Ribble Valley Borough Council
Housing & Development Control

Your ref: 3/2023/0100
Our ref: D3.2023.0100
Date: 17th April 2023

Application no: **3/2023/0100**

Address: **Land west of Preston Road Longridge PR3 3BE**

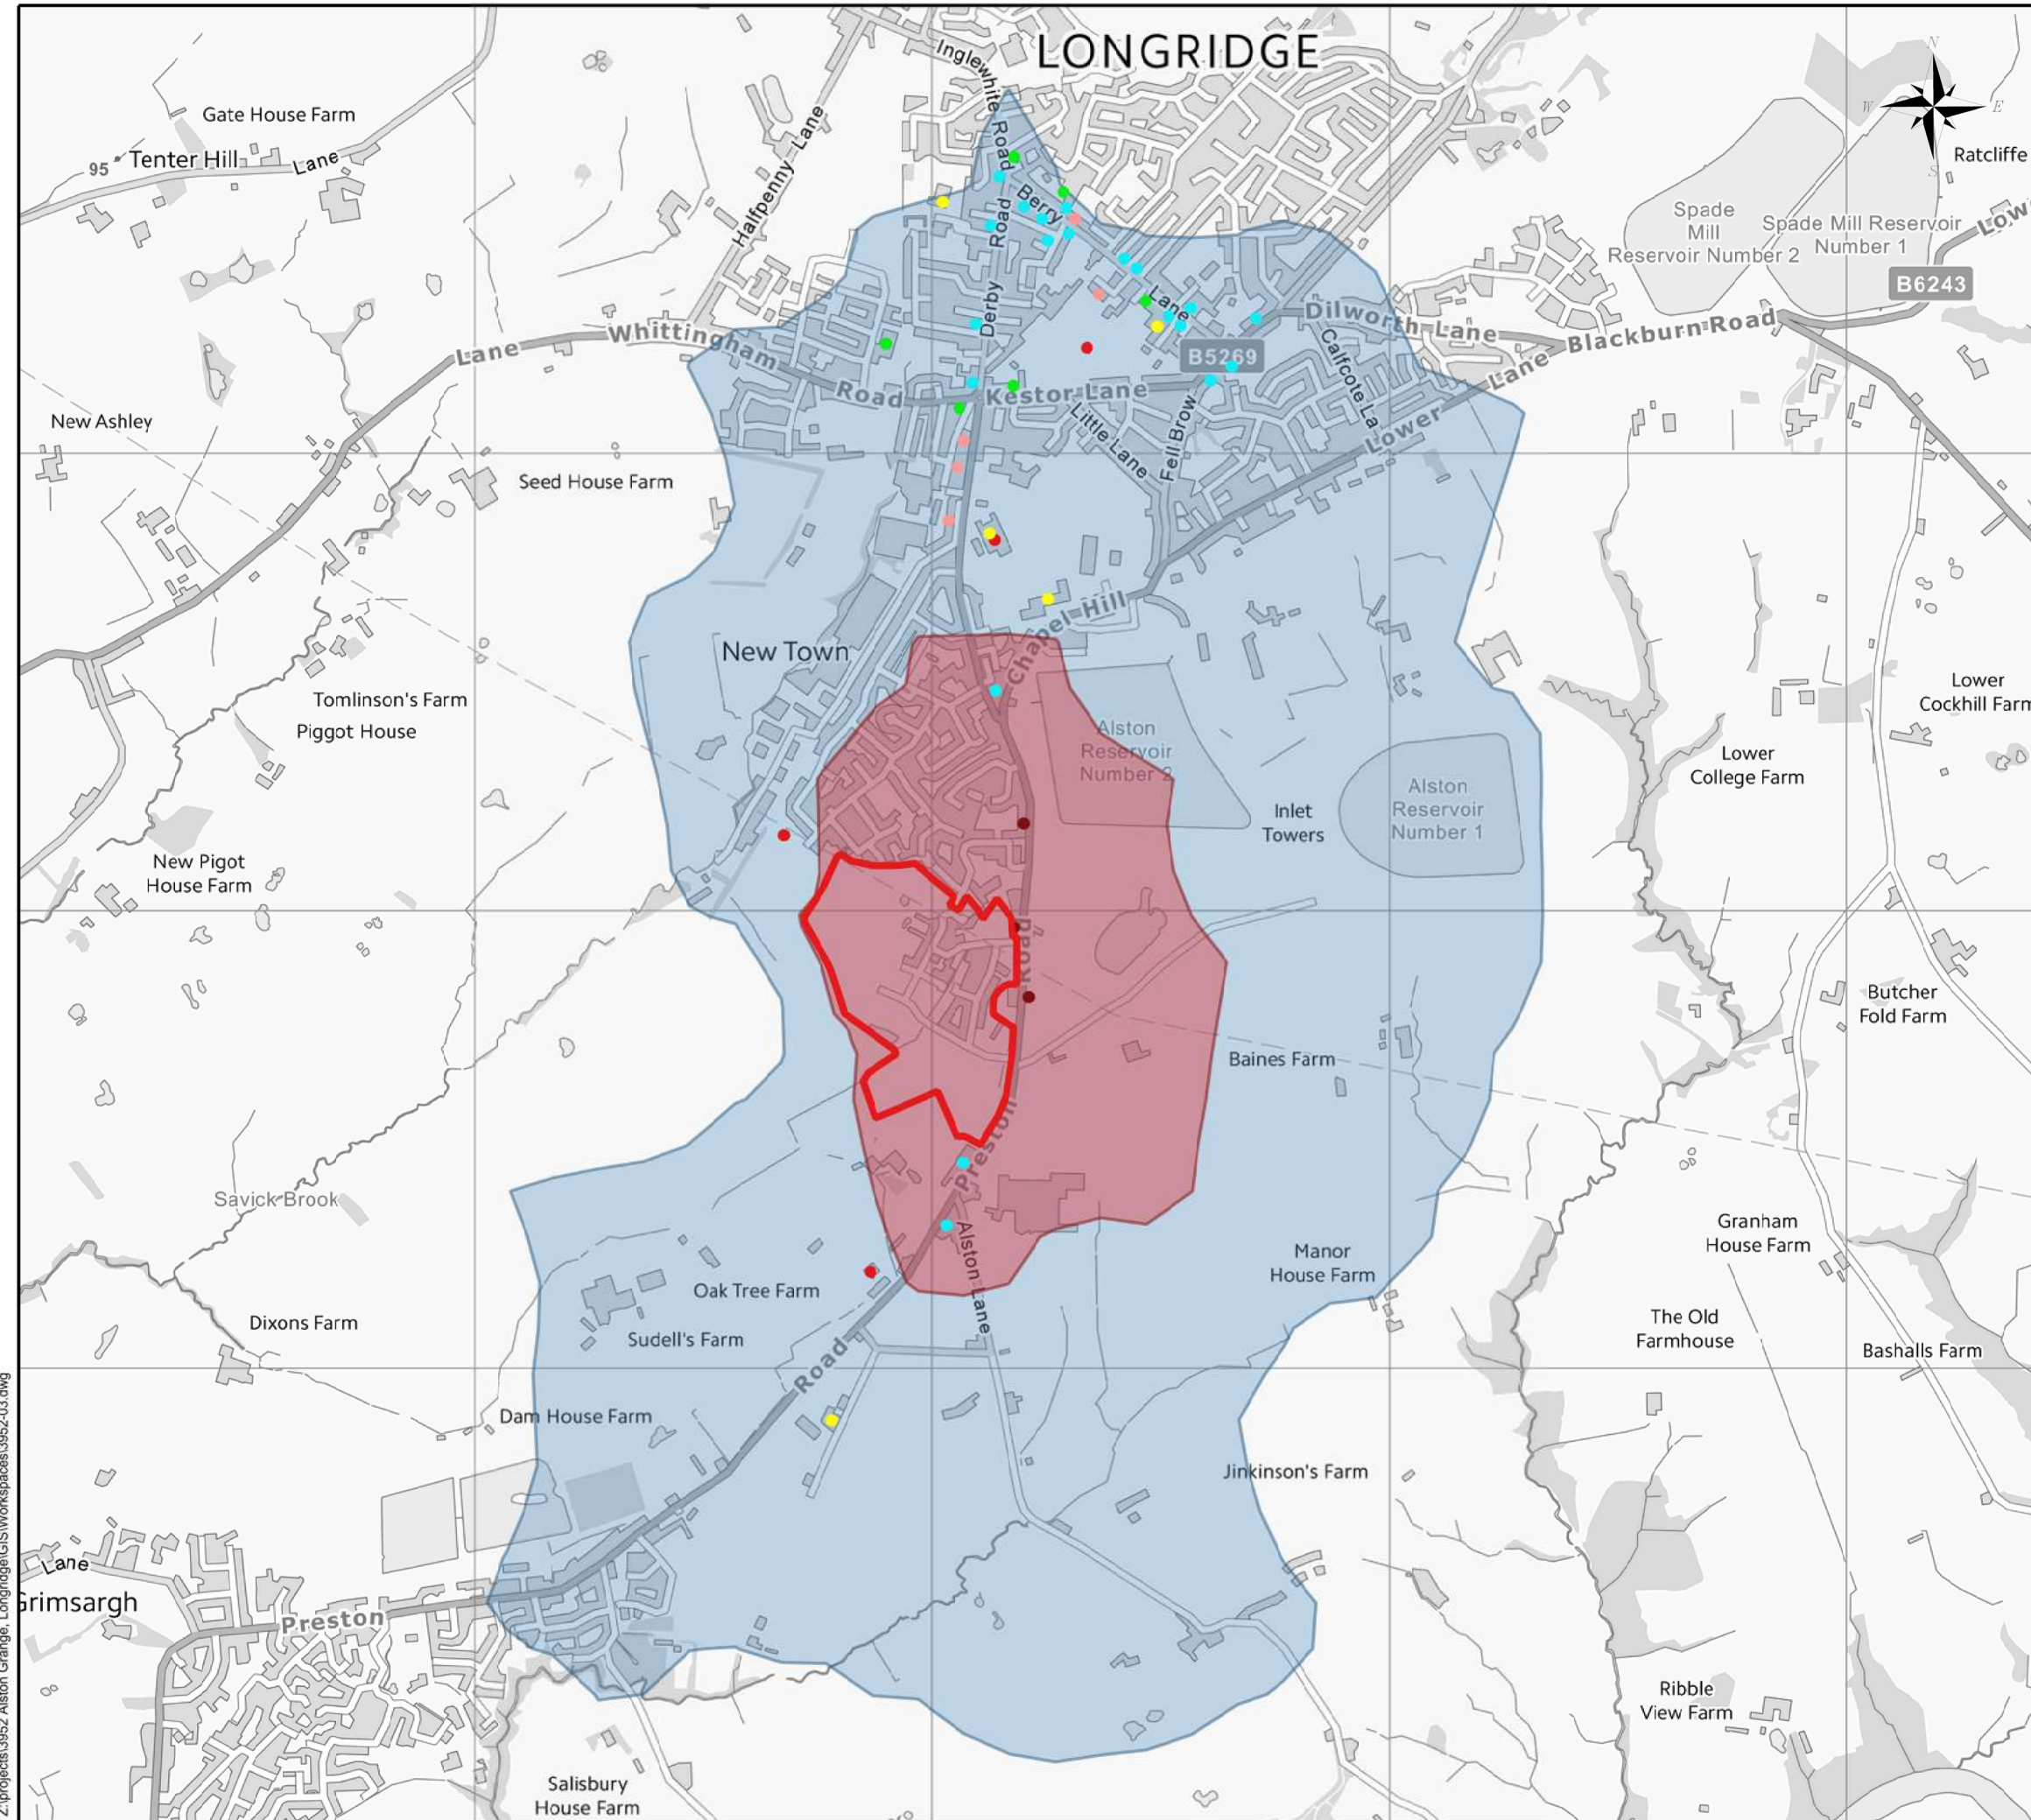
The LHA have reviewed MPSL drawing number 01 Rev S titled "Planning Layout" and are aware that the main spine road throughout the site will be 5.5m wide. However, the width of the carriageway will reduce to 4.8m when the spine road connects to a junction which serves a cul-de-sac, for example the carriageway reduces to 4.8m when serving Plots 158-166.

Despite the LHA accepting the internal carriageway width, the LHA will request that the internal carriageway serving the community centre is 5.5m wide for the full duration of its length. This is because, while the proposed community centre is located adjacent to a cul-de-sac and subsequent turning area, the internal carriageway is likely to generate more traffic than the other arms of the internal carriageway which serves a cul-de-sac. Therefore, this part of the internal carriageway should be amended.

However, the location of some of the Plots parking spaces should be revised. These Plots include 152, 158, 159, 165, 169, 209 and 251. This is due to the parking spaces being located a considerable distance away from the front of each individual Plot. This could cause occupants of the Plots to park on-street which is a concern given that these Plots are located either adjacent to a junction or a turning area, which is limited in size as mentioned above. Therefore, the LHA request that these spaces are relocated, or the developer provides a walkway from each Plots parking area to their garden and in turn rear door. These changes should be shown on an amended plan.

The LHA have reviewed MPSL drawing number 01 Rev S titled "Planning Layout" and are aware that the site will provide an off-road pedestrian link from Pond 6 to Pond 7, which connects the site to the community centre and the surrounding site. As well as providing internal off-road links to the already approved 3.5m cycleway which is located at the northern boundary of the site.

The LHA welcome these links but will request the route is paved, drained and lit to an adoptable standard.
